6024 CS
United Utilities Water PLC
Developer Services & Asset Protection
Thirlmere House
Lingley Mere Business Park
Lingley Green Avenue
Great Sankey
Warrington WA5 3LP

Your ref: 3/2012/0480
Our ref: DC/12/2465
Date: 21-JUN-12

Location: Workshop/Office Building Roadside Farm, Preston Road, Alston PR3 3BL
Proposal: Change of Use from office/workshop into 2 residential dwellings

Proposed Site Layout

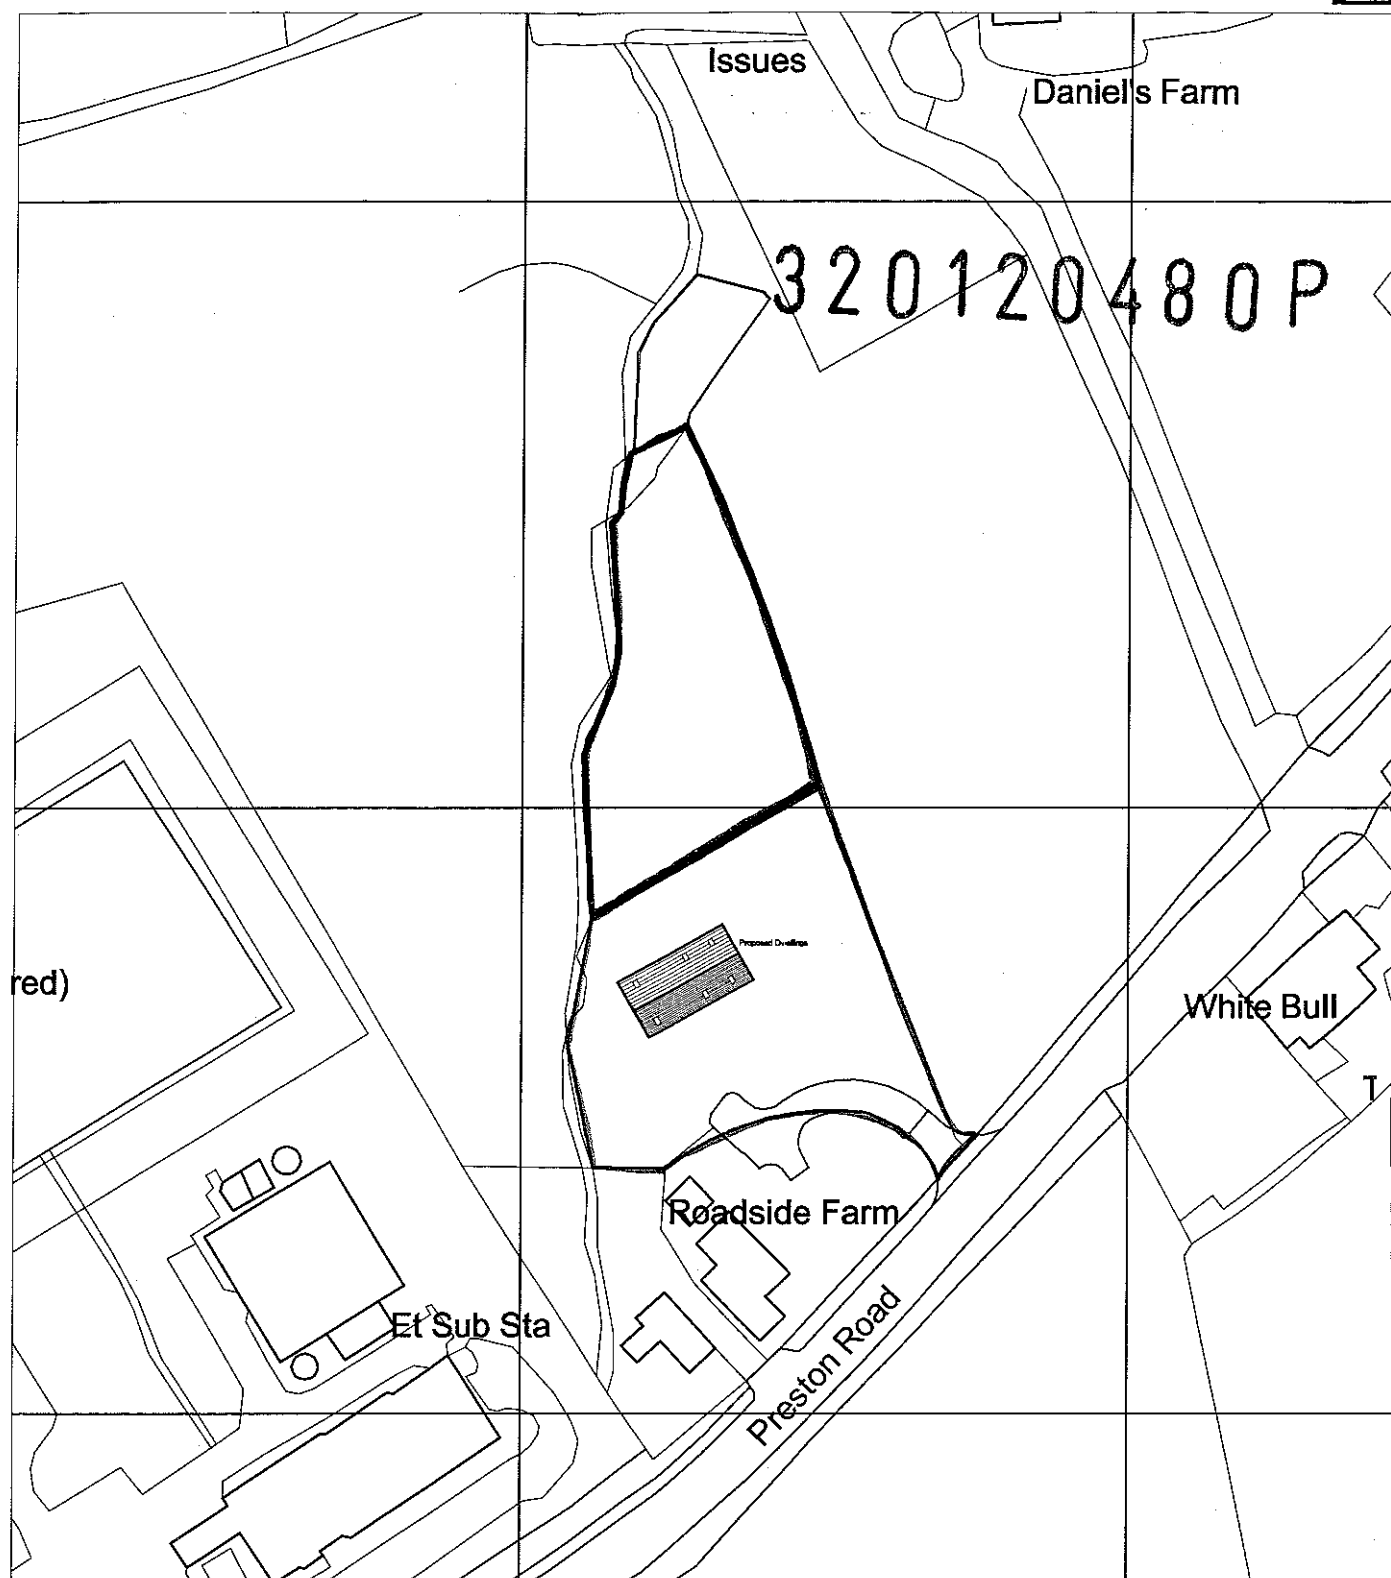
I do not object to the proposed development, however a large diameter water main crosses the site with another large diameter water main to the north of the site. As we need access for operating and maintaining it, we will not permit development in close proximity to the main.

A modification of the site layout, or diversion of the main at the applicant's expense, may be necessary.

This should be taken into account in the final site layout, or a diversion will be necessary, which will be at the applicant's expense.

You will need an access strip of 10m.
